**RE: Carlisle and Menaul Development North of I-40, northwest corner of Carlisle and Menaul
Albuquerque, New Mexico**
Submittal Dated May 2, 2025
Via email cvermillion@bhinc.com

Bohannon Huston would like to thank you for reviewing and commenting on the submitted Carlisle and Menaul Traffic Impact Study. Please find the following responses from Bohannon Huston to the review comments dated May 16, 2025.

**SITE PLAN AND CROSS SECTION
EXHIBIT**

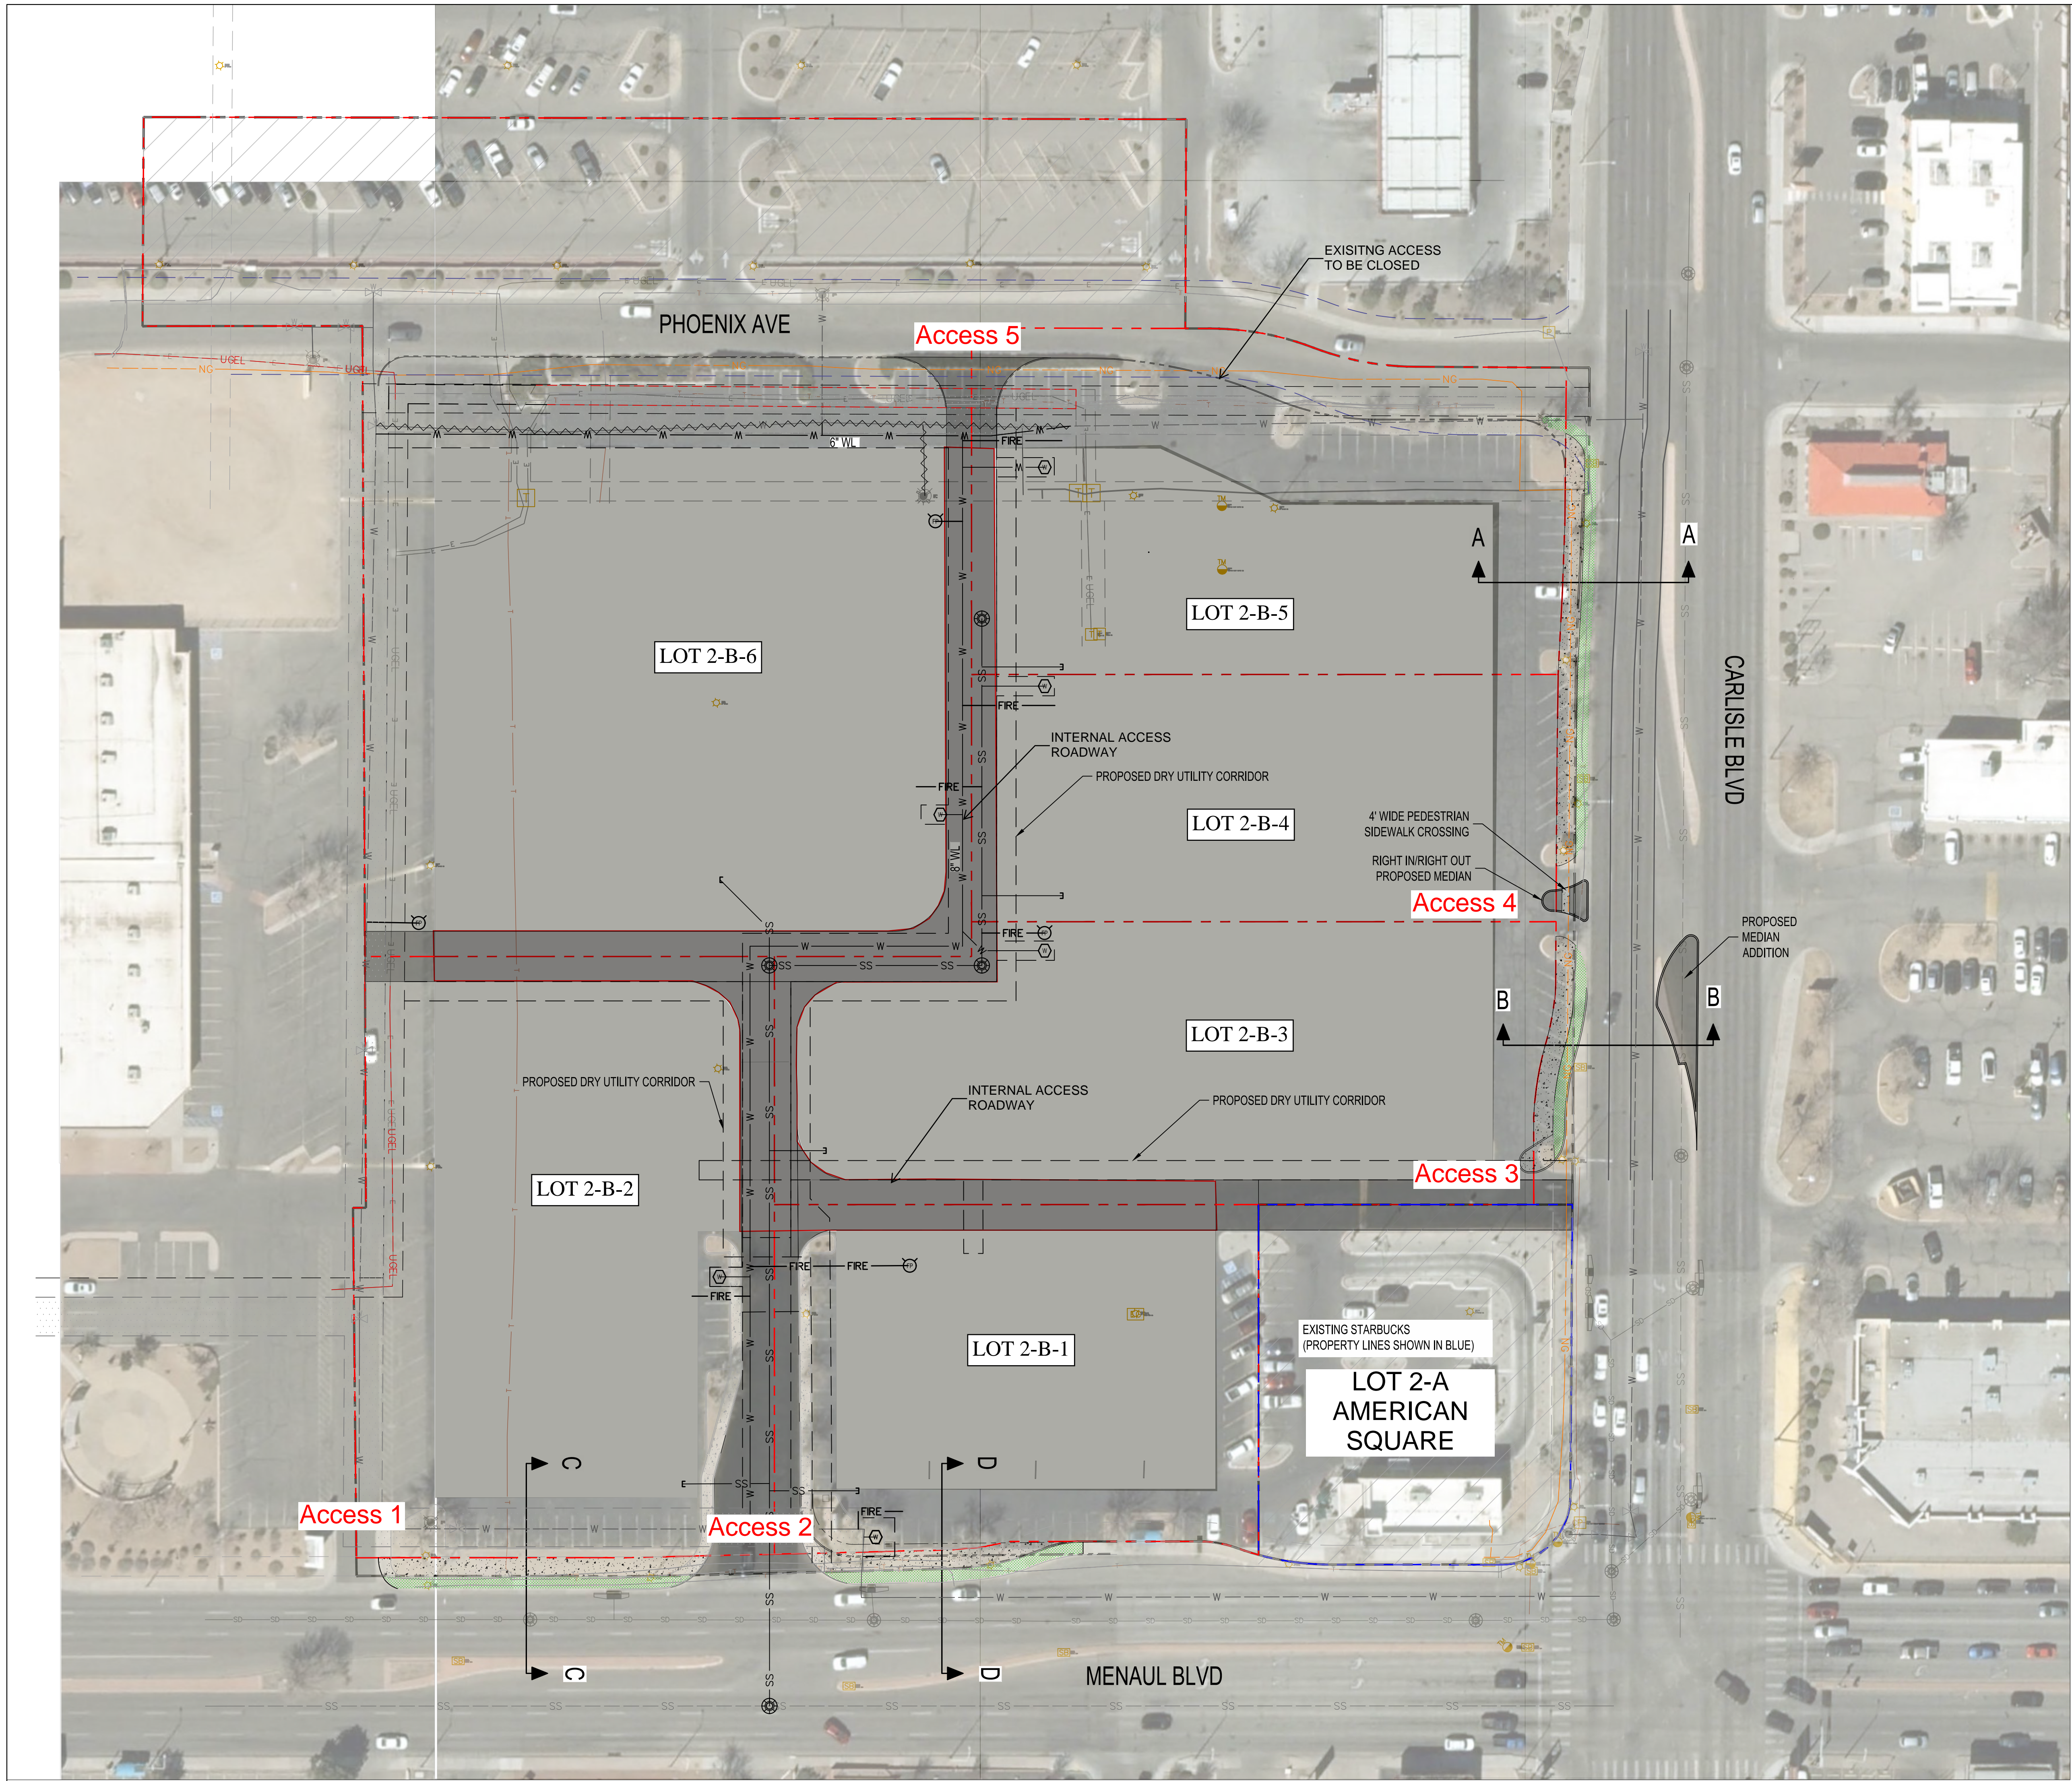
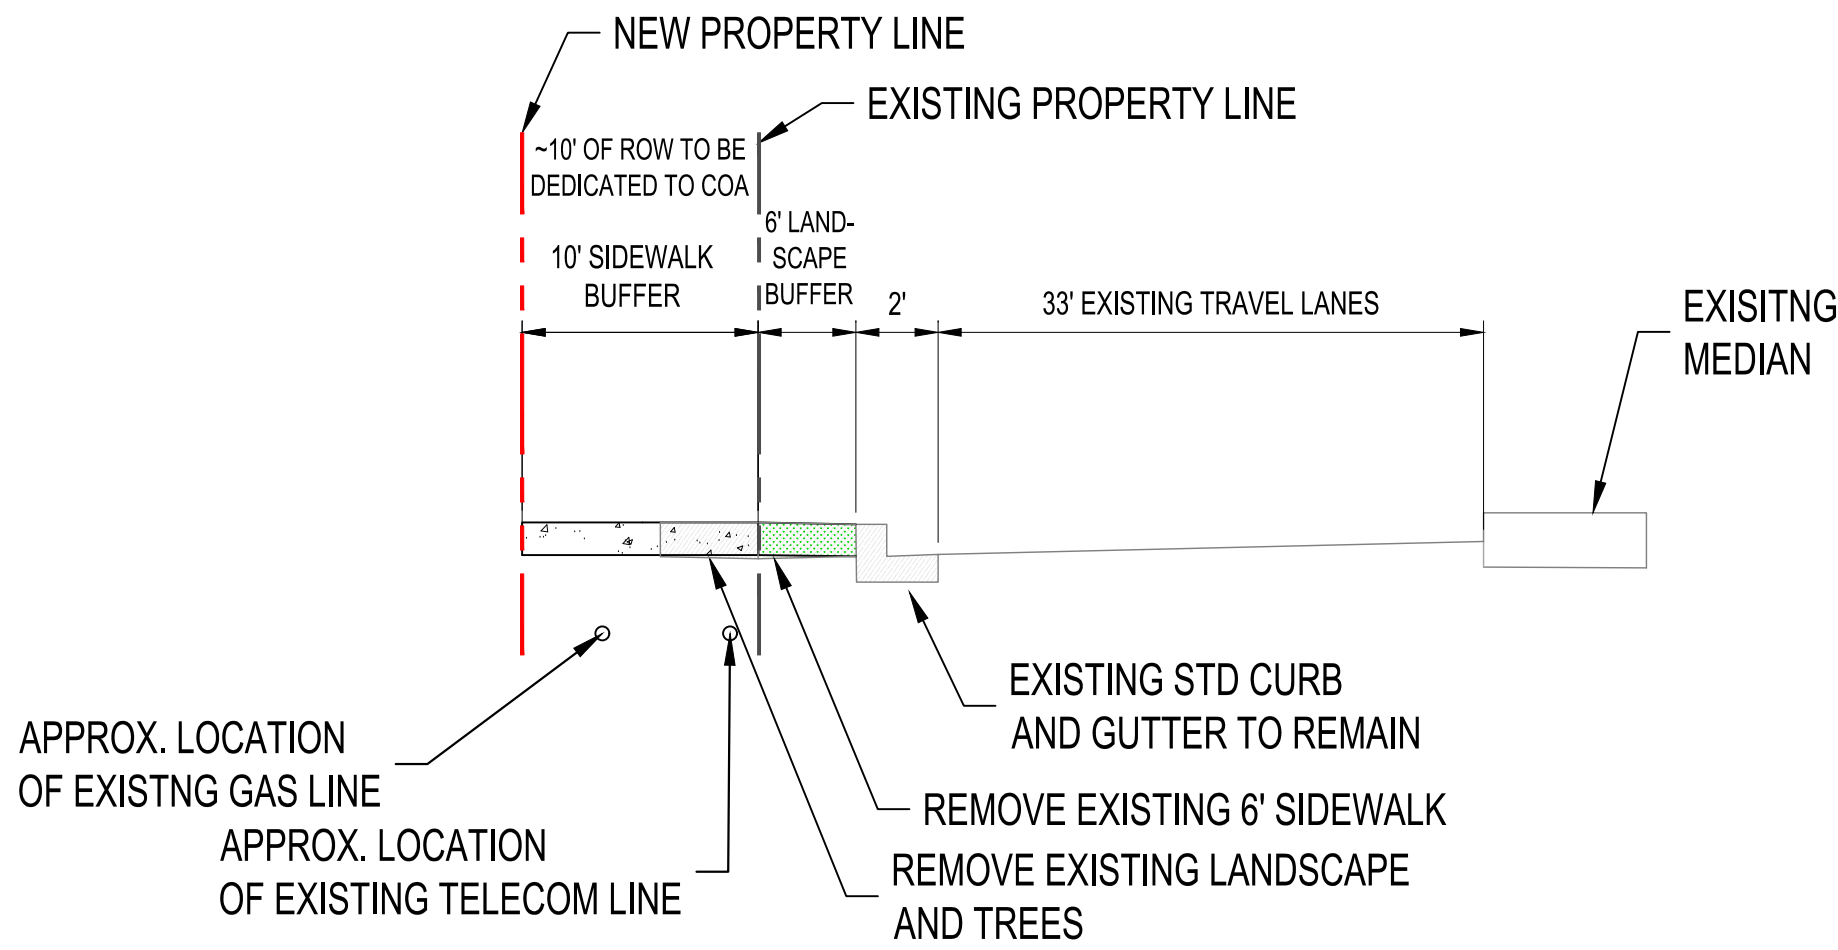
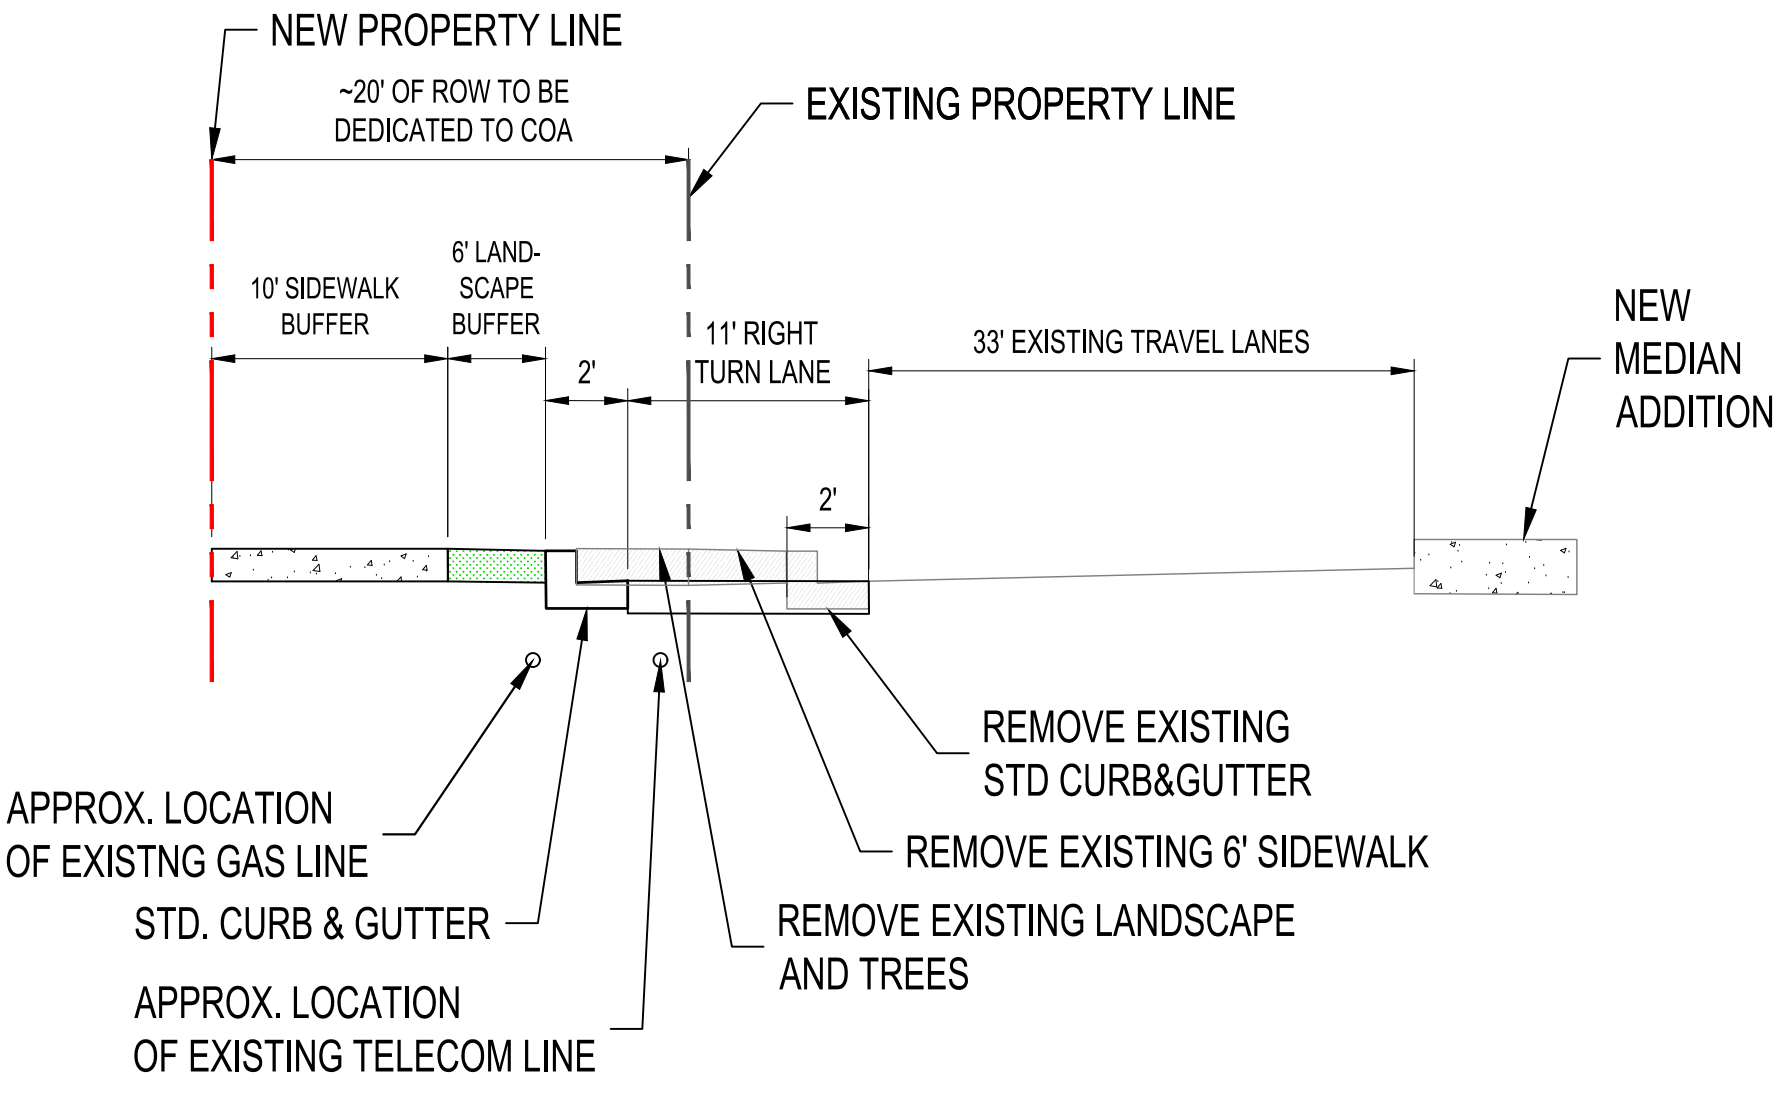
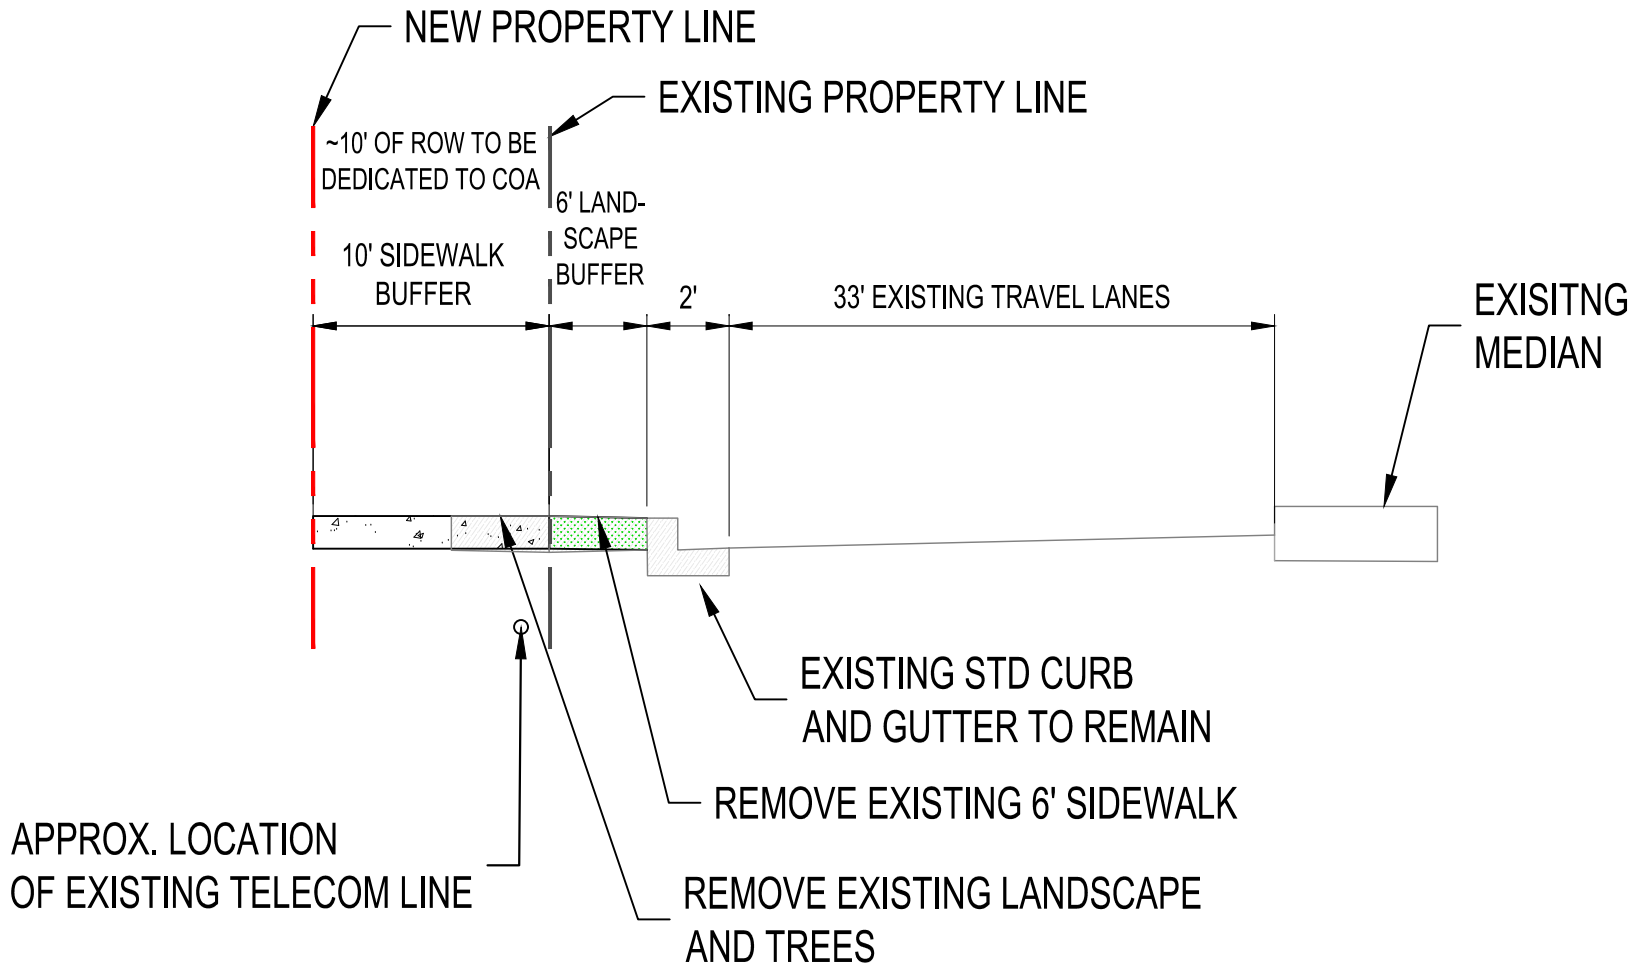
1. The development should reduce the number of conflict points by reducing access points and/or movements. This work should be more than striping to be effective. Or provide engineering studies documenting that more access points for a commercial development is safer than less access points.

2. The development should reduce the widths of its proposed access points to reduce conflict area and provide an engineering design to enhance visibility of vulnerable road users crossing its access points.

3. The development should provide enhanced and upgraded pedestrian facilities along its frontage with Carlisle Blvd and Menaul Blvd. Or verify crash locations by providing detailed crash diagrams based on crash reporting narratives that identify actual locations of crashes and those crash movements at the intersections and segments of roadway within these study intersections to support no enhanced mitigations.

Bohannon Huston Response: In Coordination with the City of Albuquerque, Bohannon Huston has updated the access point at Carlisle and access point 4 to a right-in/right-out only. In existing conditions this access is a full access. This access serves the adjacent business on the east side of Carlisle, so we are proposing to build an island in the access that only allows right-in/right-out movements but still allows access to the east side of Carlisle. See the attached drawing showing this preliminary design.

Bohannon Huston Response: Some existing access points are remaining protected in place with no changes and others will be reduced to minimize the widths. Access 1 on Menaul is currently 20' in width and will remain. Access 2 on Menaul is currently 44' in width. The development is proposing to retain this access point due to larger vehicles accessing the site in the future for deliveries. Access 3 on Carlisle is currently 25' in width. This access is partially on the property of Starbucks and therefore the development cannot adjust this access point. Access 4 on Carlisle is currently 30' and will be designed with a 12' entrance lane, a 12' exit lane with a 12' island that forces a right turn exit. This island will include a 4' sidewalk that extends through it for enhanced pedestrian visibility and decreased distance in conflict areas. Access 5 on Phoenix will be designed to have a width of 26'. The last access that exists on Phoenix will also be reduced to 24' wide.

Bohannan Huston Response: We are proposing to meet the sidewalk and buffer criteria from the City of Albuquerque on Carlisle and on Menaul as shown in the attached. This will include a 6' buffer with a 10' sidewalk along the frontage of the development property on Carlisle and on Menaul.
